PLANNING BOARD

February 3rd, 2014

Project Name: "118 on Munjoy Hill" Condominium
12 unit residential, and 2 unit commercial, condominium
Project ID: #2013-255
Project Address: 118 Congress Street
CBL: 16-D-2
Applicant: Ed Theriault, EMT, LLC (118 Condominiums, LLC)
Planner: Jean Fraser

SECOND FLOOR PLAN
A1.02

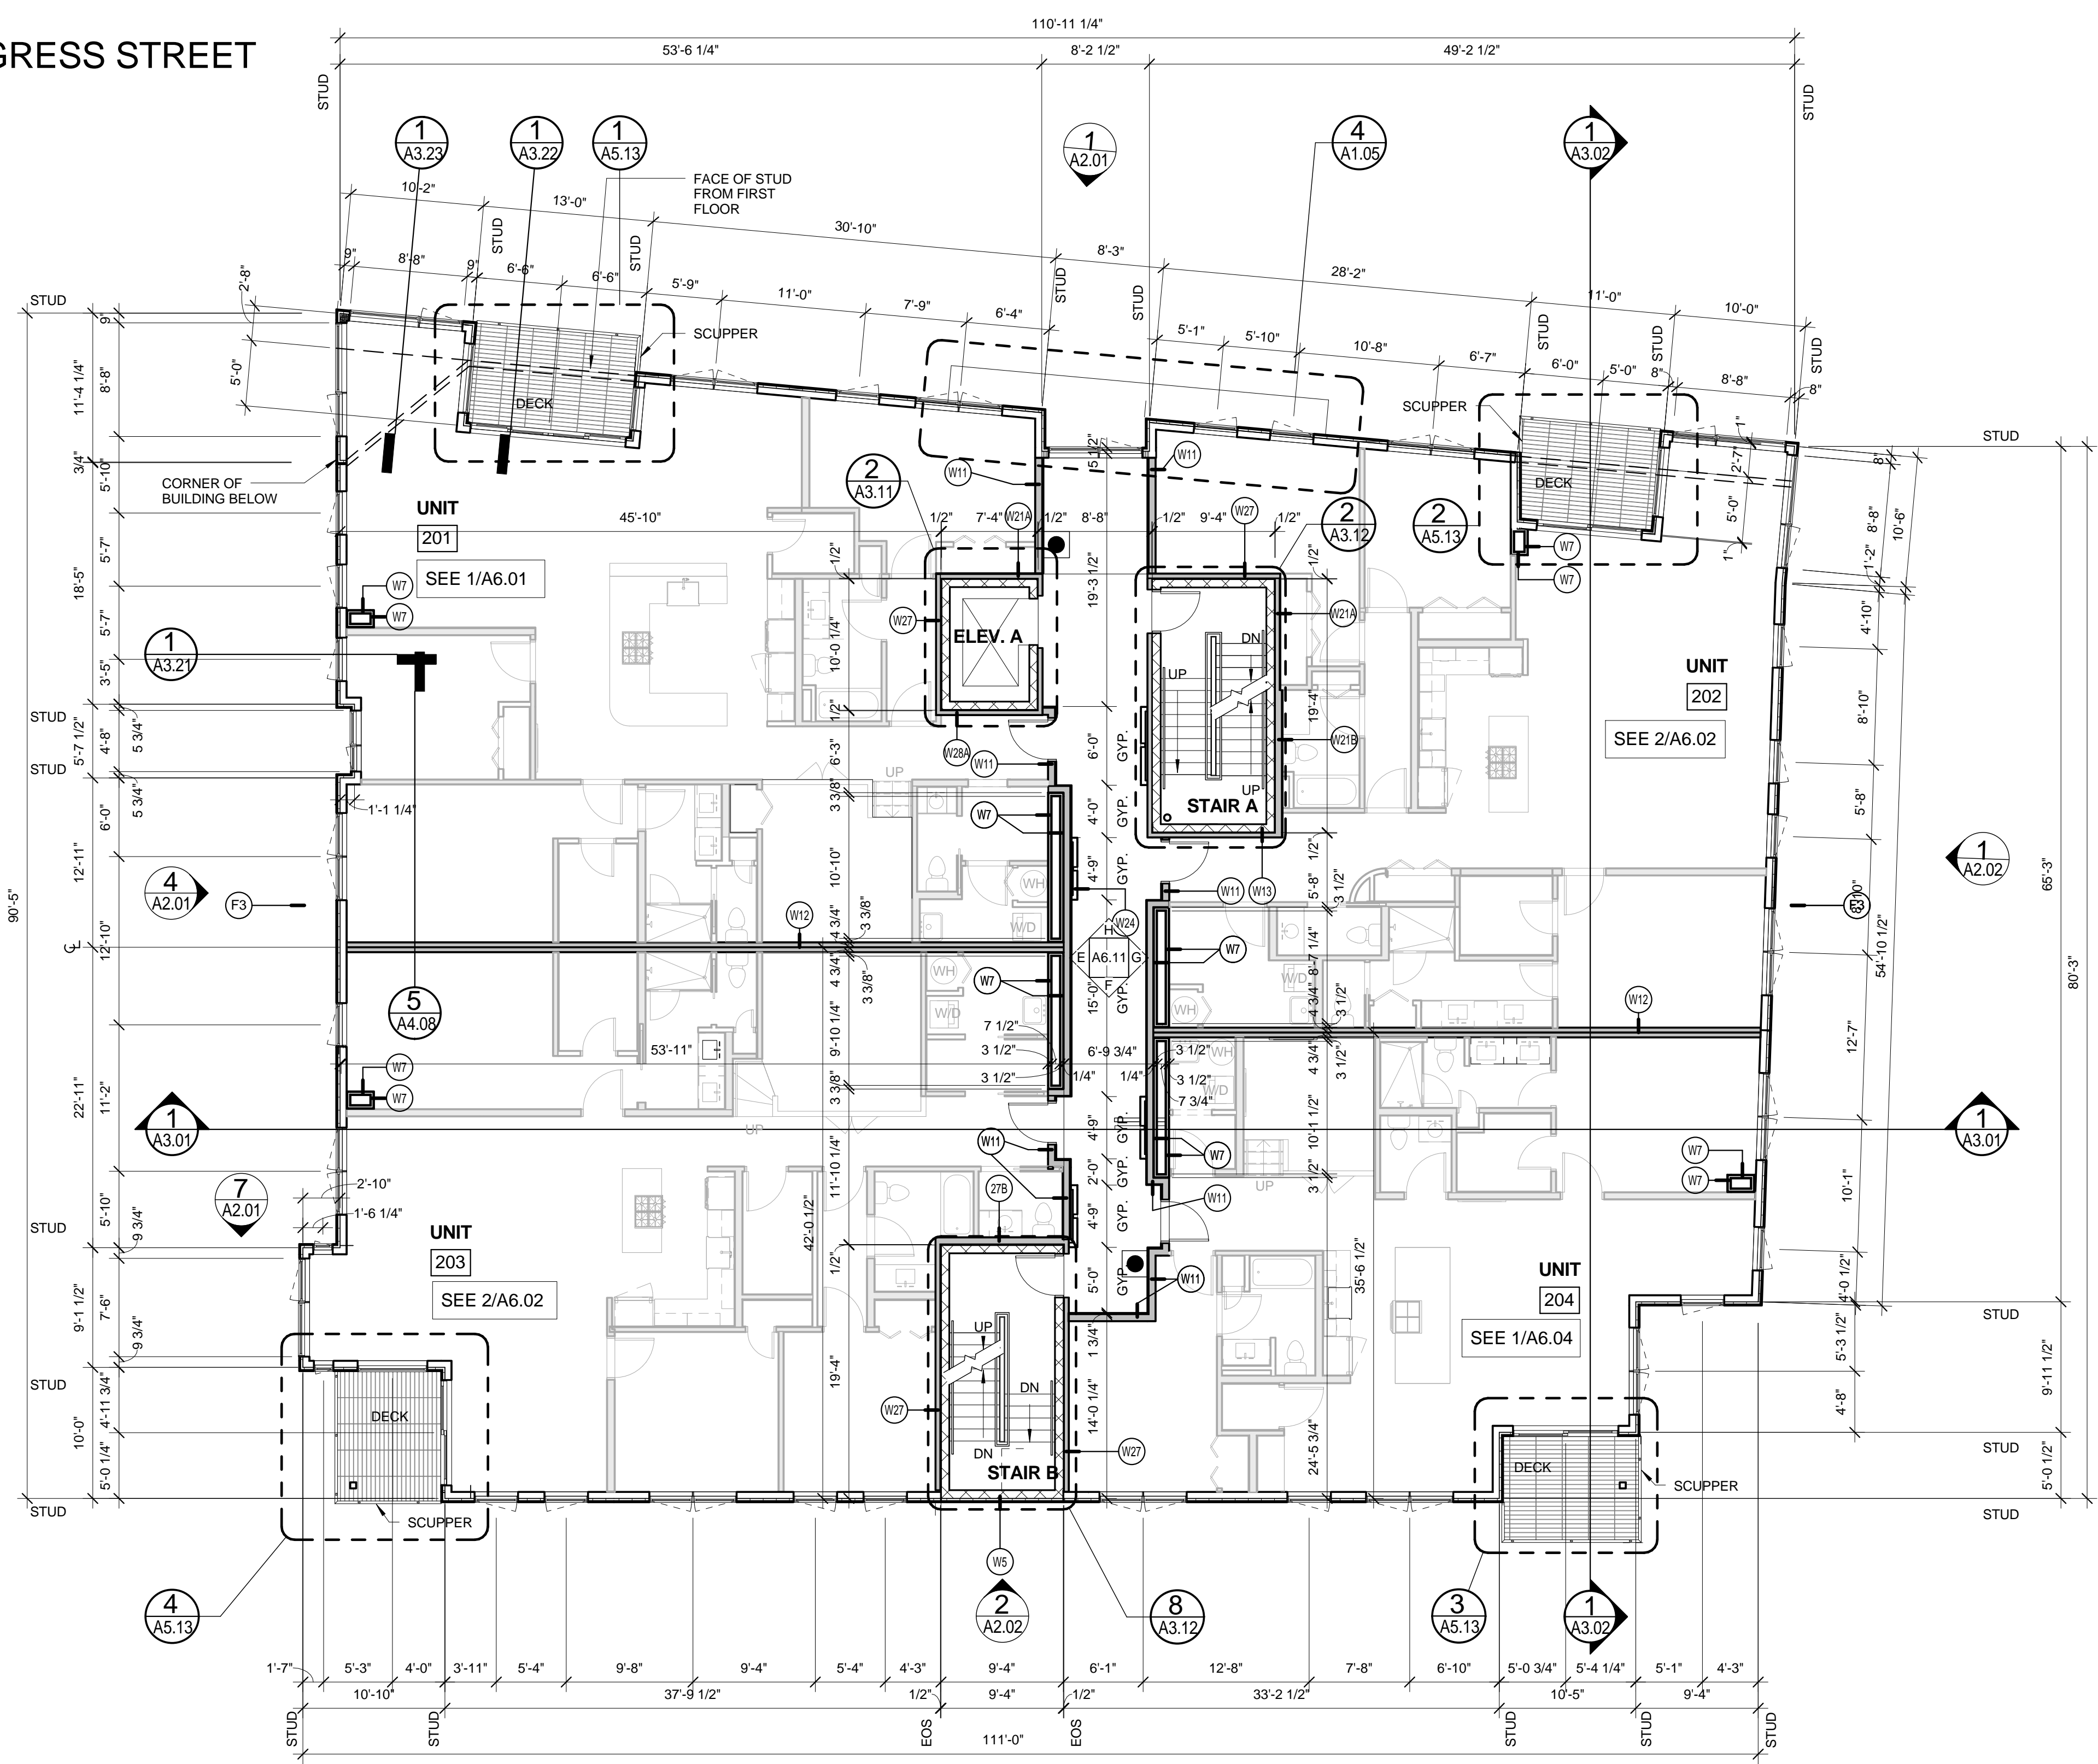
- i. The applicant shall submit a revised building design that results in the decks on St Lawrence Street being within the property boundaries while maintaining the current quality of design in regards to facade articulation and variation of form, for review and approval by the Planning Authority prior to signing of the Subdivision Plat; and
